SITE UTILITY PLAN

SMELKER - HCI BUILDING
LOT 2, PUMP IT BABY SUBDIVISION

Utility Plan_V1.pdf Markup Summary

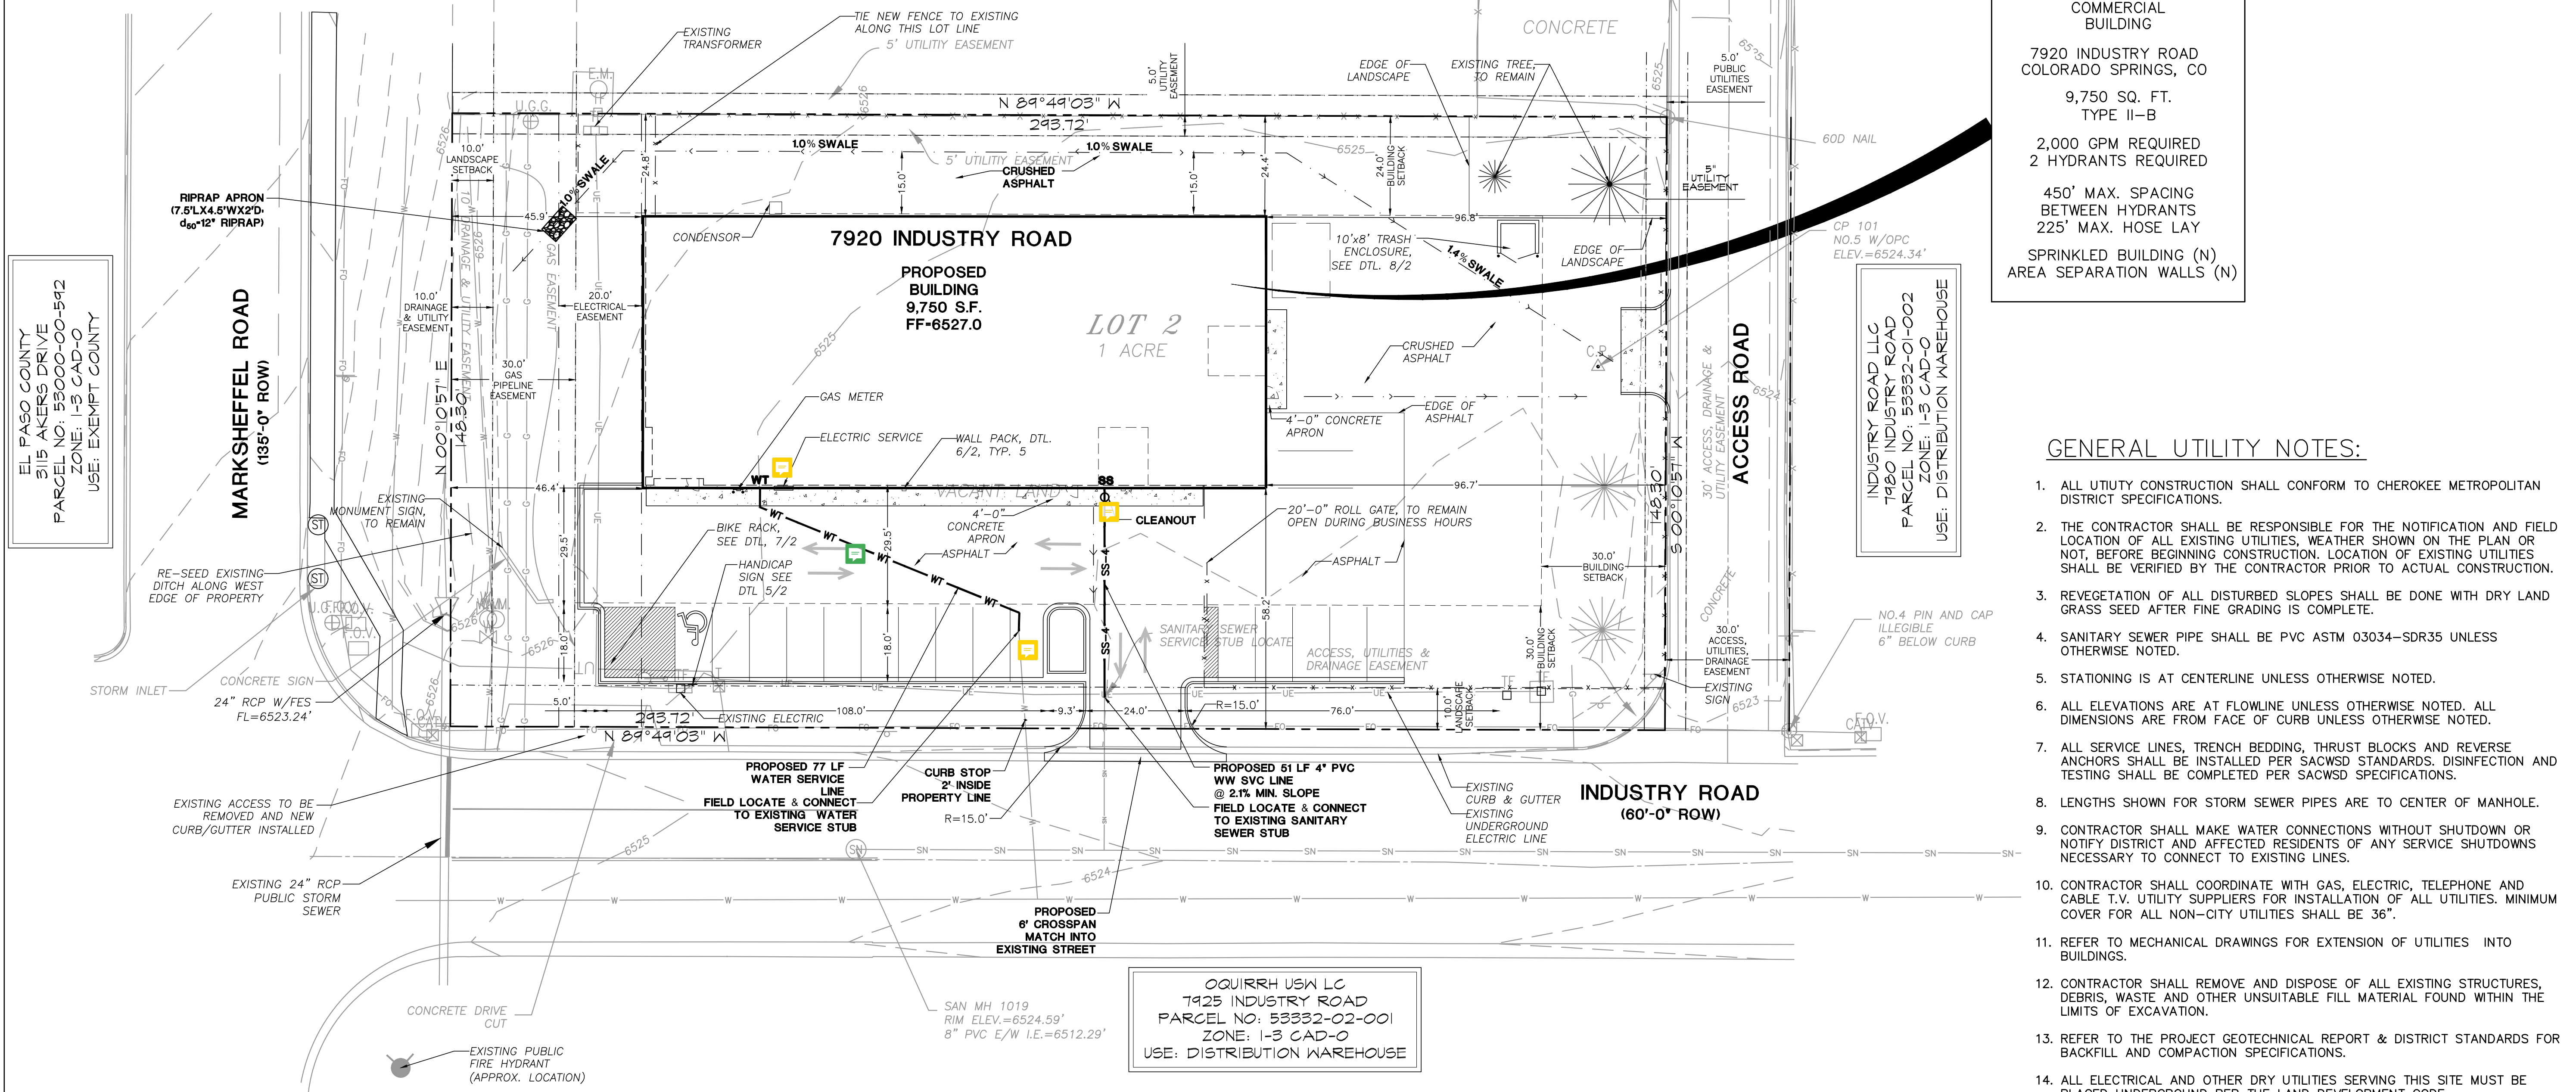
Add curb return specs
